SCOPING OPINION:

Proposed Hampshire Water Transfer & Water Recycling Project

Case Reference: WA010002

31 August 2023

**Title**  
Figure 1.2  
Scoping Area  
Sheet 1 of 8

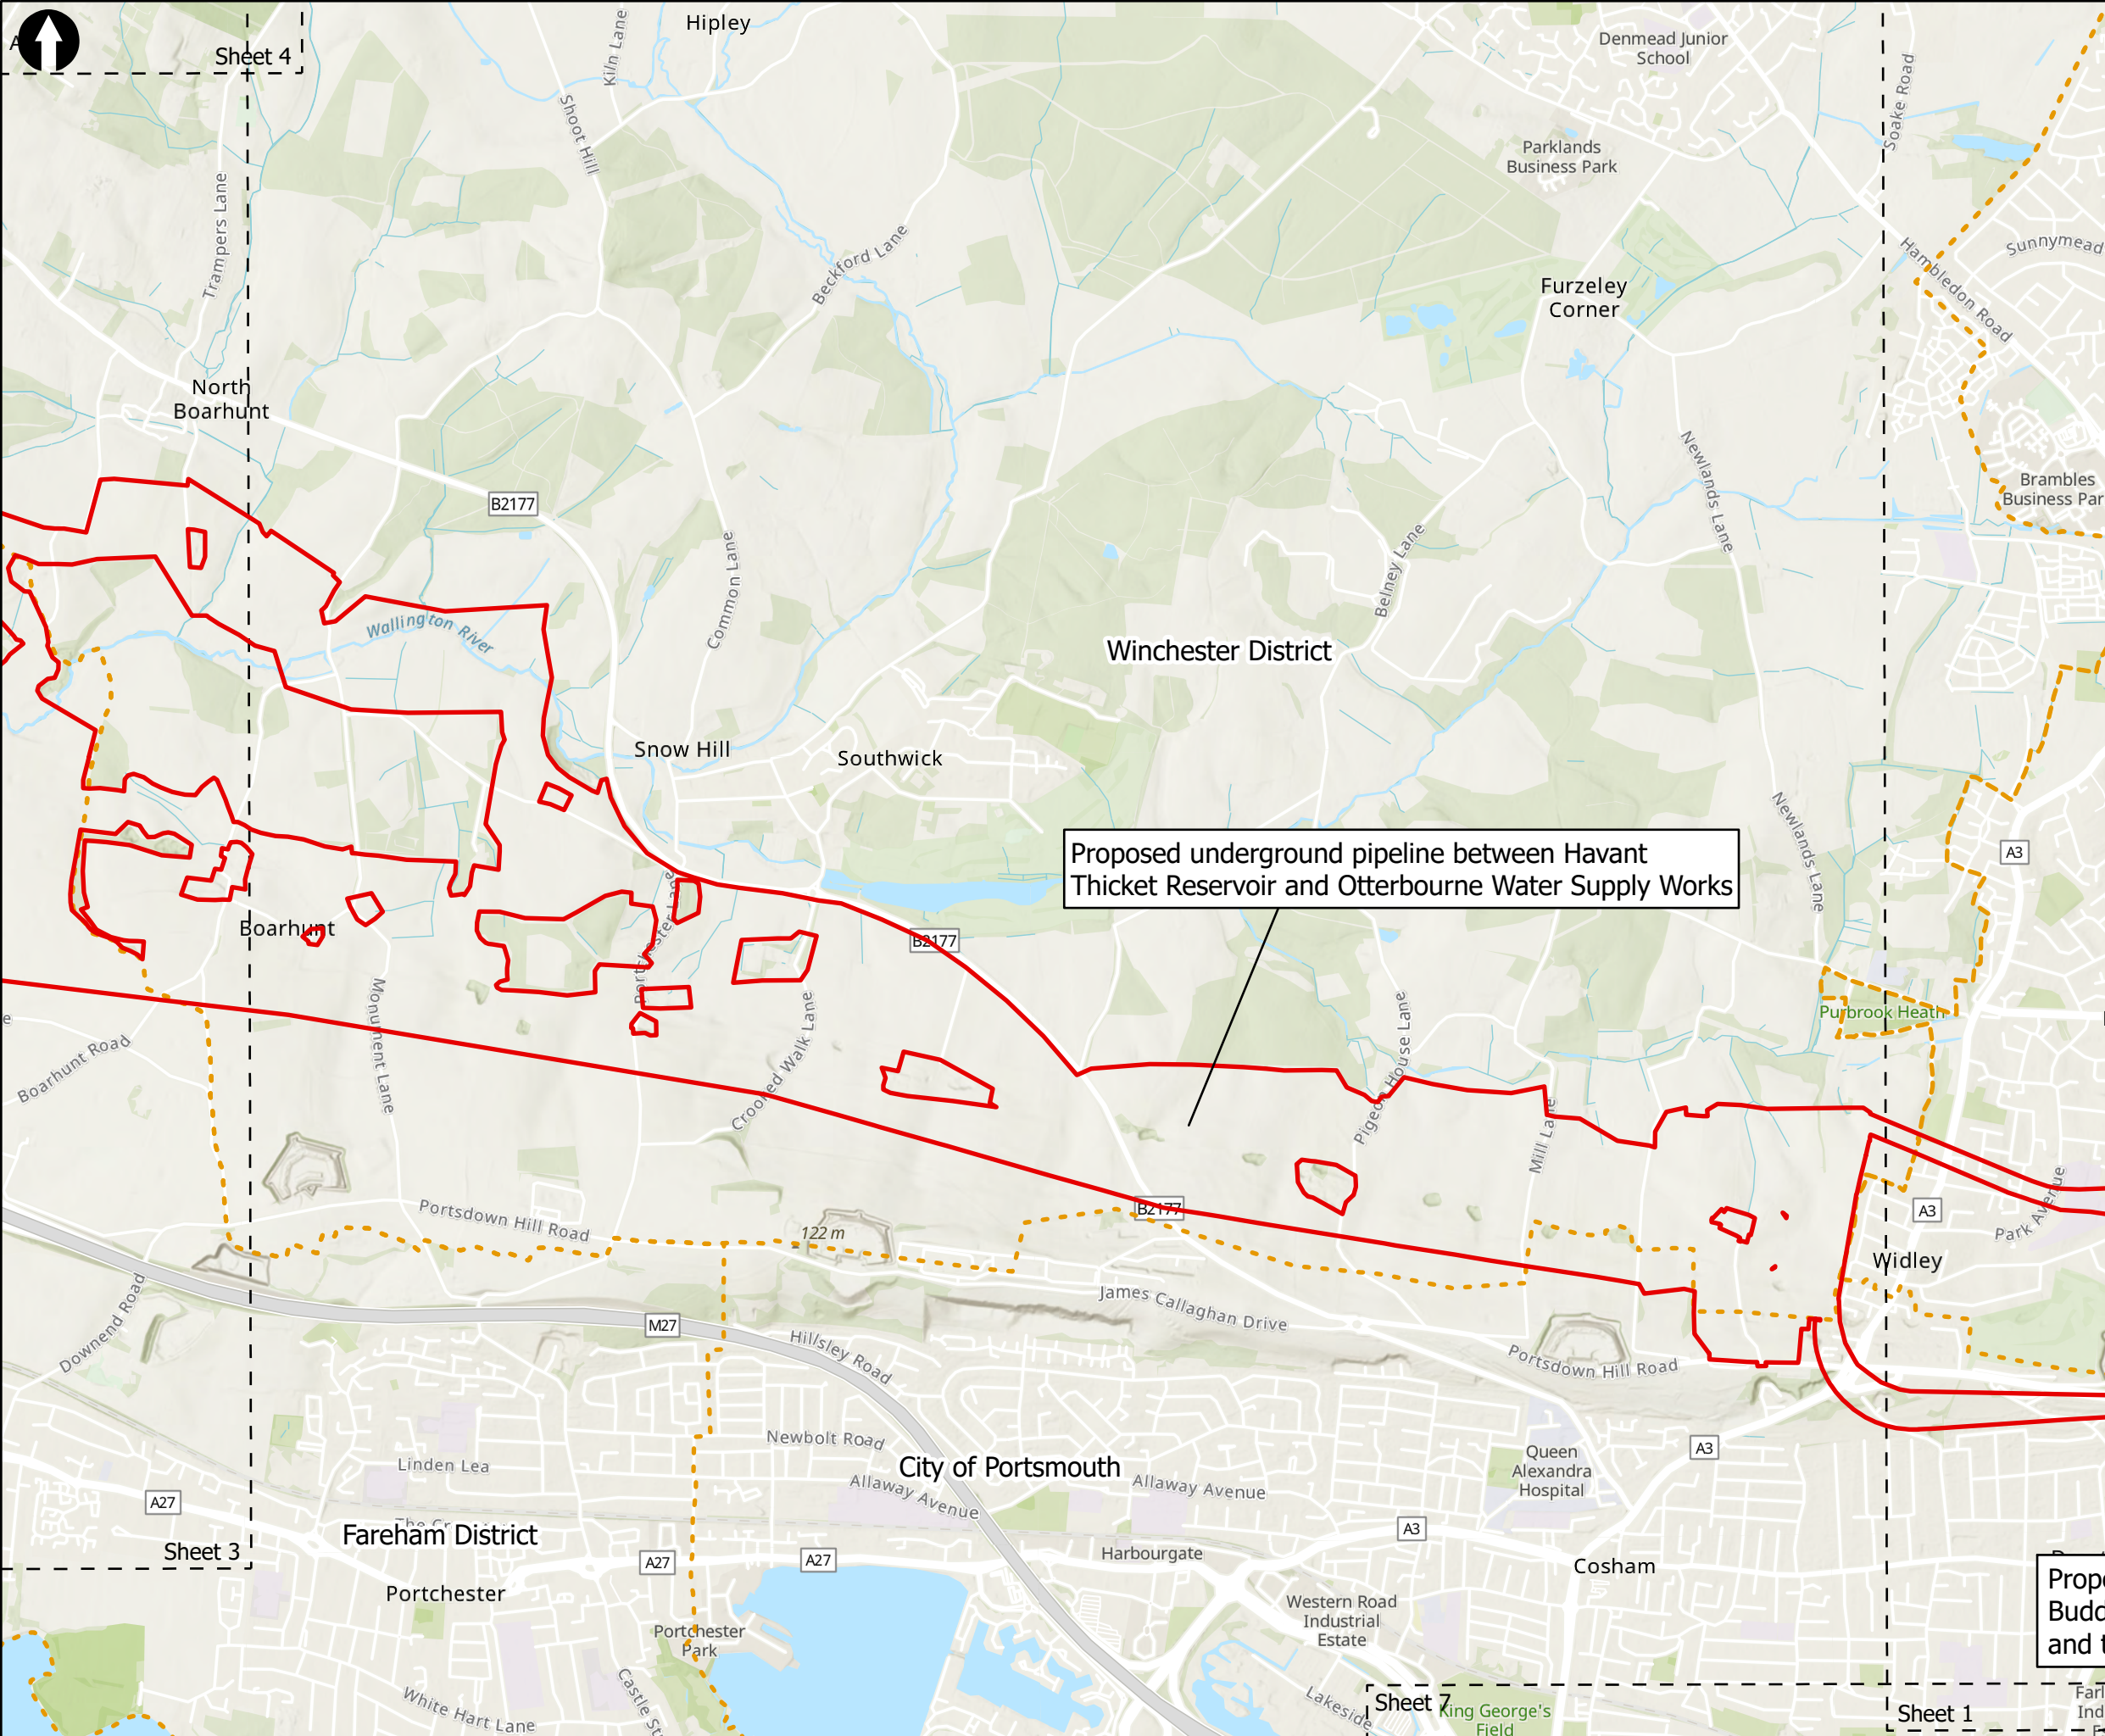
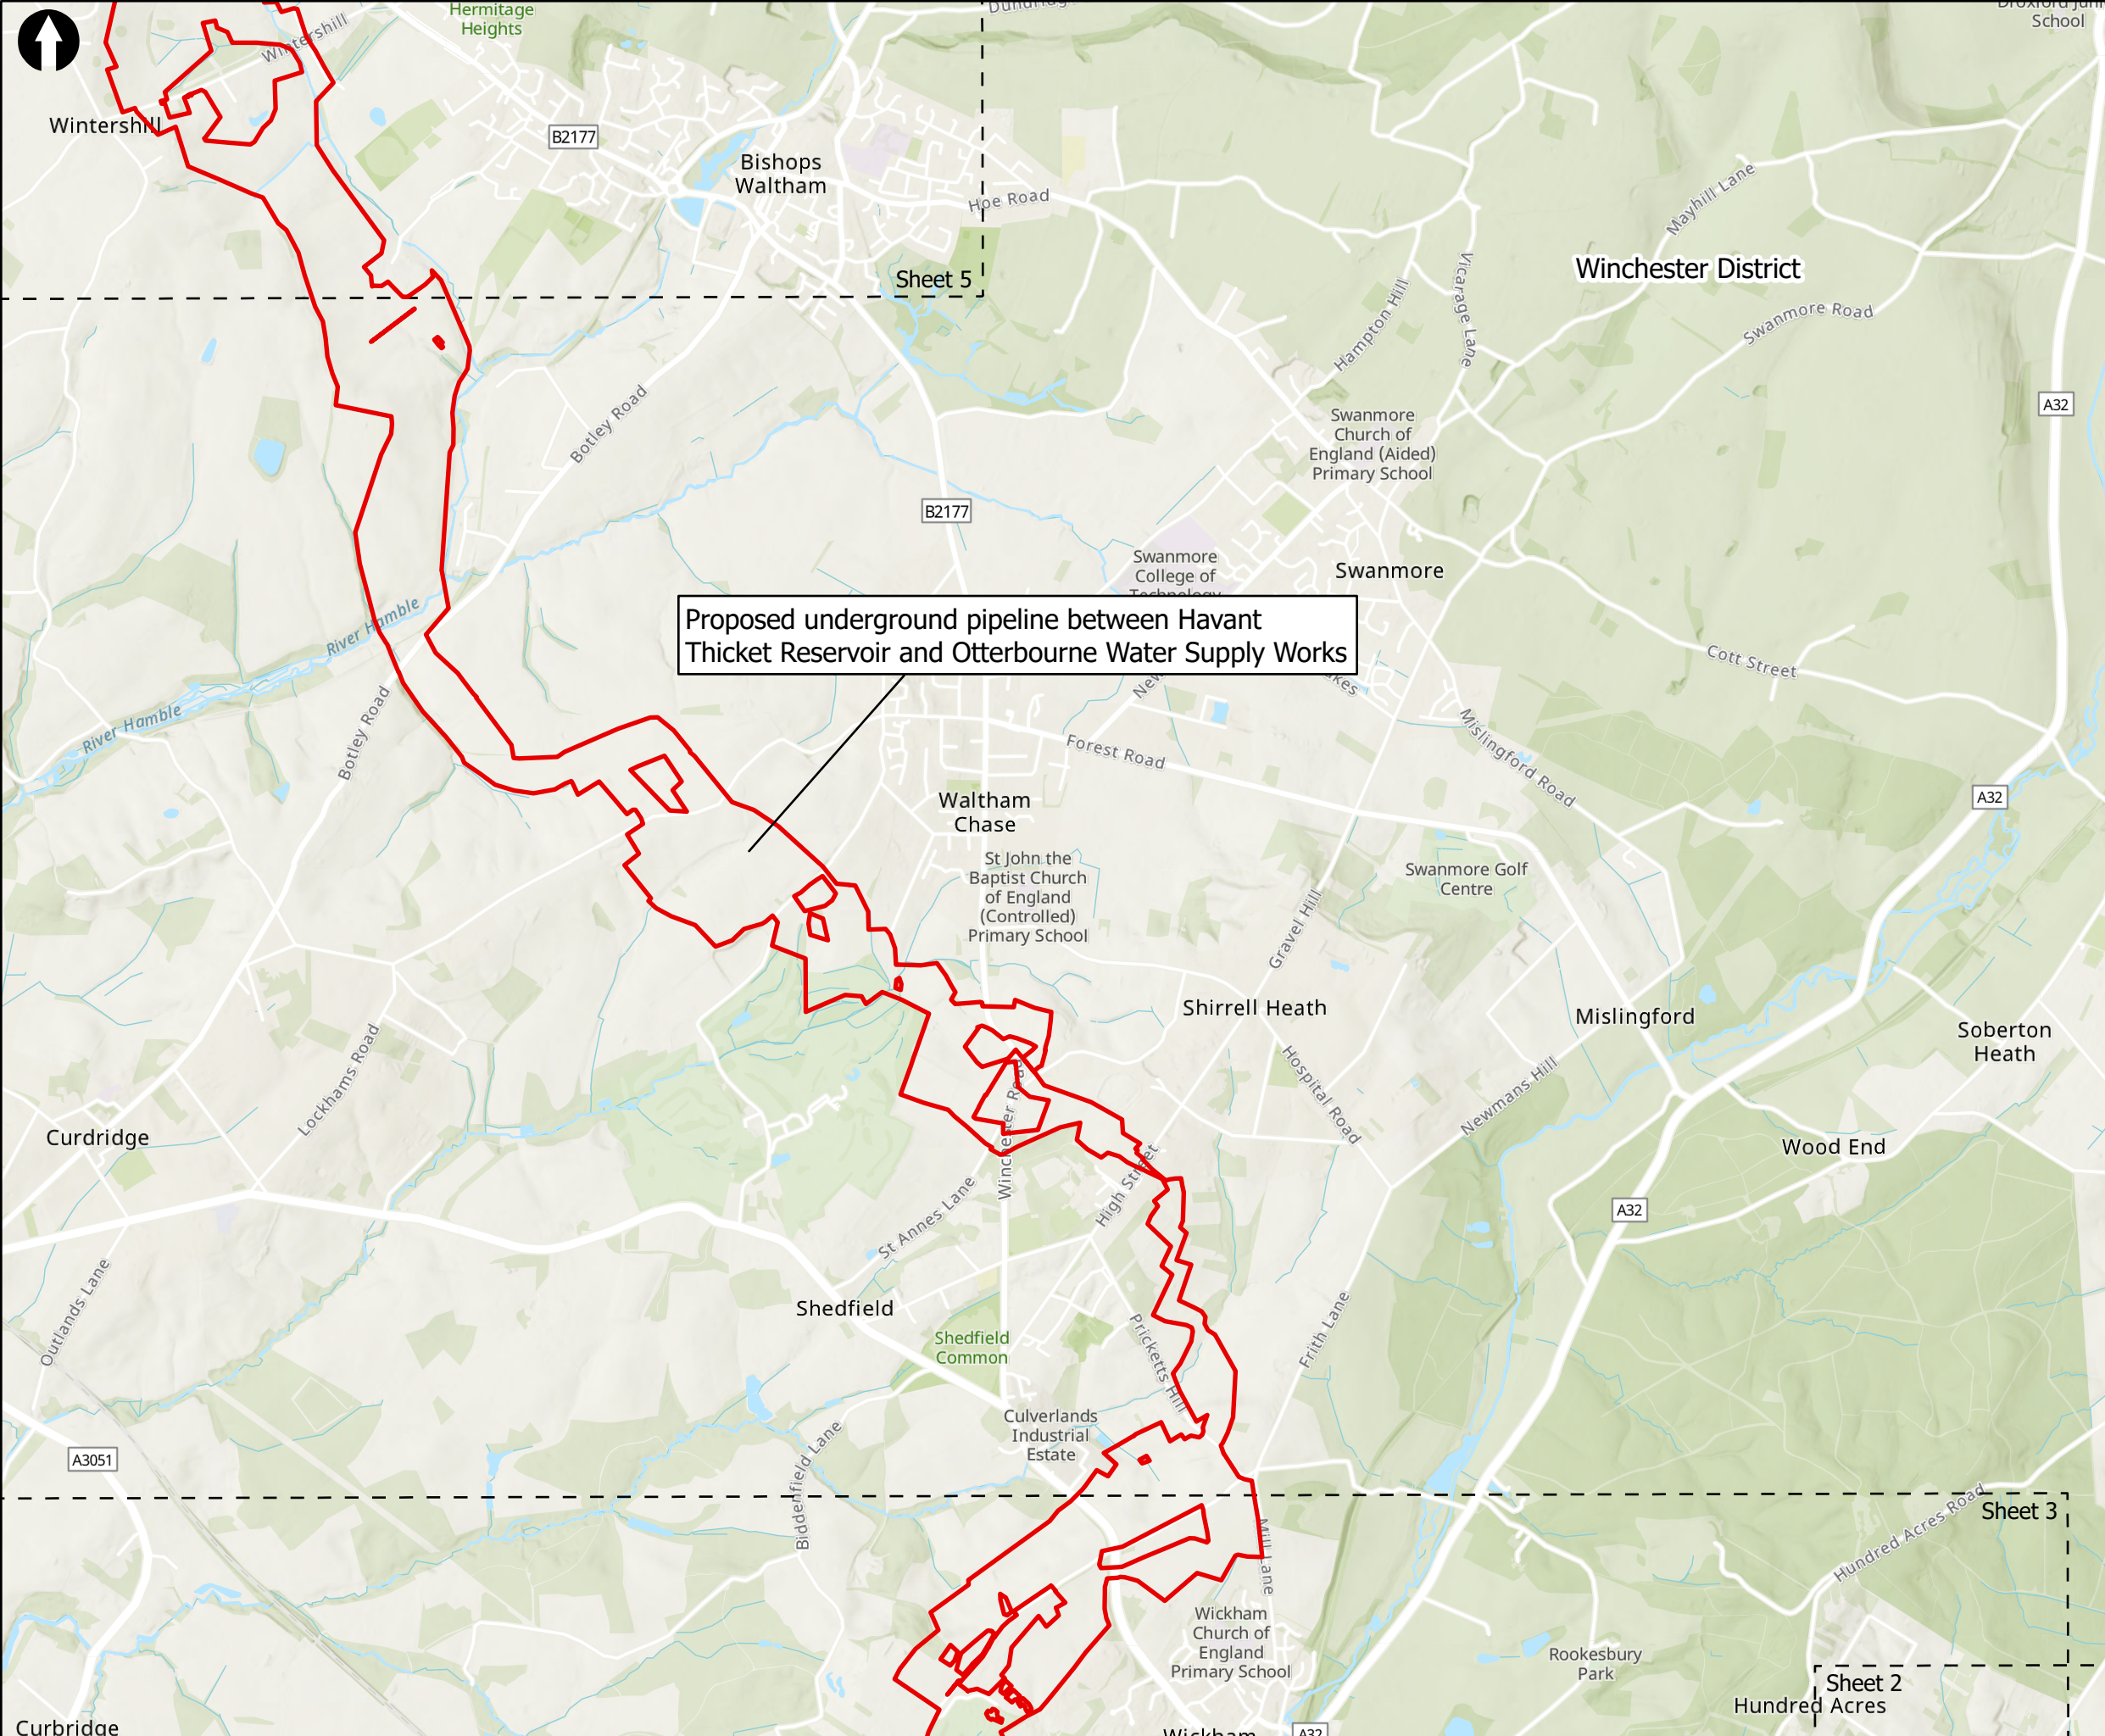
2.2.2	Chapter 4	Order limits	<p>The scoping area shown on Figures 1.1 and 1.2 is proposed to be refined further through scheme development and EIA processes prior to confirmation of the Order limits within the DCO application. The ES should include an explanation of any changes made following scoping,</p>

ID	Ref	Description	Inspectorate's comments
			including how environmental effects have been considered in finalising the Order limits.
2.2.3	Chapter 4	Alternatives	Paragraph 4.1.4 of the Scoping Report references a separate document, Scheme Development Summary, from the Applicant's consultation in summer 2022, which provides further detail about alternatives assessed during the development of the project. The Inspectorate considers that this document should be submitted as part of the ES, eg as a technical appendix, together with any other relevant documentation that has been used to inform the consideration of alternatives through the Regulator's Alliance for Progressing Infrastructure Development (RAPID) gated process.
